CITY OF ALBUQUERQUE

December 19, 2014

**Re: Sandia Prep School Running Track Reconstruction
Drainage Plan with Engineer's Stamp Dated 12-2-14
(E16D012)**

D:\SEC\PROJECTS\114653 Sandia Preparatory School\ENGINEERING\GDD\PLANSET\4 DRAINAGE PLAN.dwg Dec 02, 2014 10:47am Saved By: jmaesam

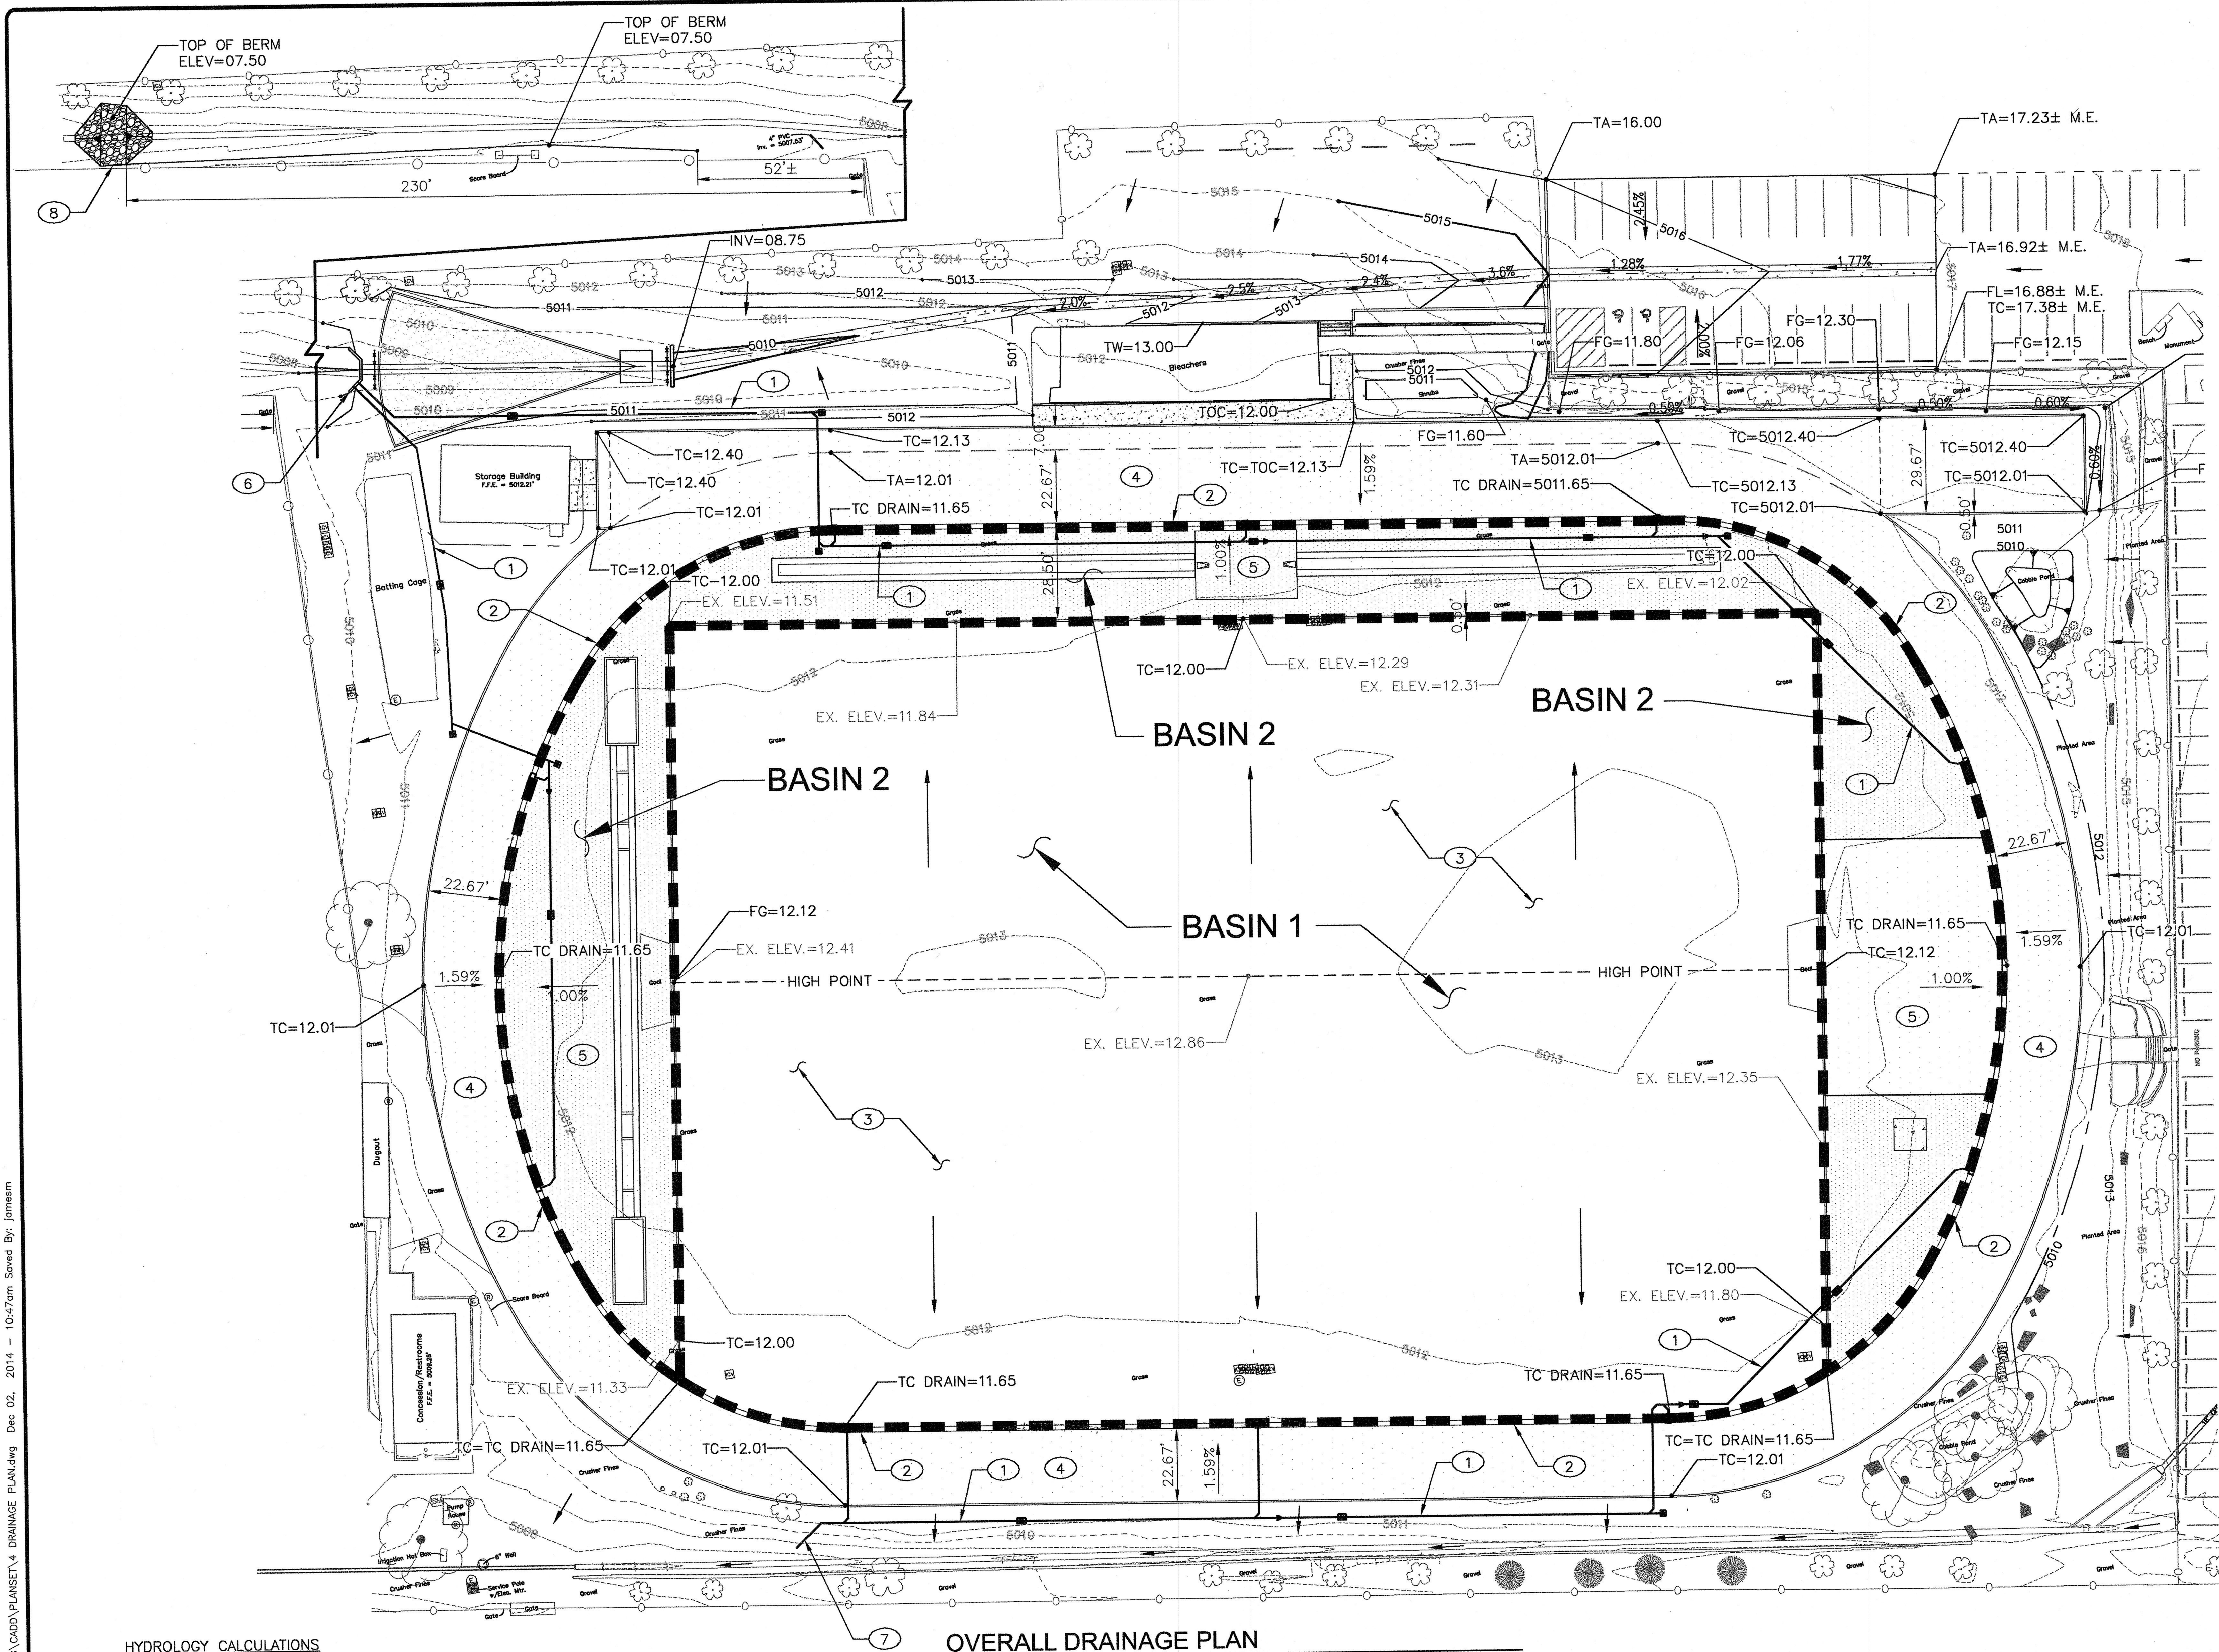
1. Always discuss if the 100 year Flood Plain is on the site or not. Include a FIRM map or a narrative about it. Include all assumptions for your calculations such as what Zone the site is in.

2. The First Flush for this site was based on 0.44 inches multiplied by the impervious area. Per the City Drainage ordinance, the 90th Percentile Storm Event, which is 44 inches, is to be managed. Reduce 0.44 inch by the 0.1 inch for the initial impervious abstraction in Table A-6 of Section 22 of the DPM. Multiply the remaining 0.34 inch by your impervious area. This is the portion to retain.

3. State the volume that is being provided by the First Flush. Show the water surface elevation on the plan. The proposed berm is being placed in an existing drainage swale that should be carrying at least 33.29 cfs. Demonstrate that flow will still fit within the swale where the berm is located.

4. It appears the existing pond may have existing capacity for the new flows from the site. Consider taking the additional drainage directly to the existing pond instead. Account for the additions that have been done for this site since the original Master Drainage Plan. The retention / wetland portion of the pond can be counted toward the First Flush.

5. Show the existing 10 inch storm pipe under the bleacher pad.
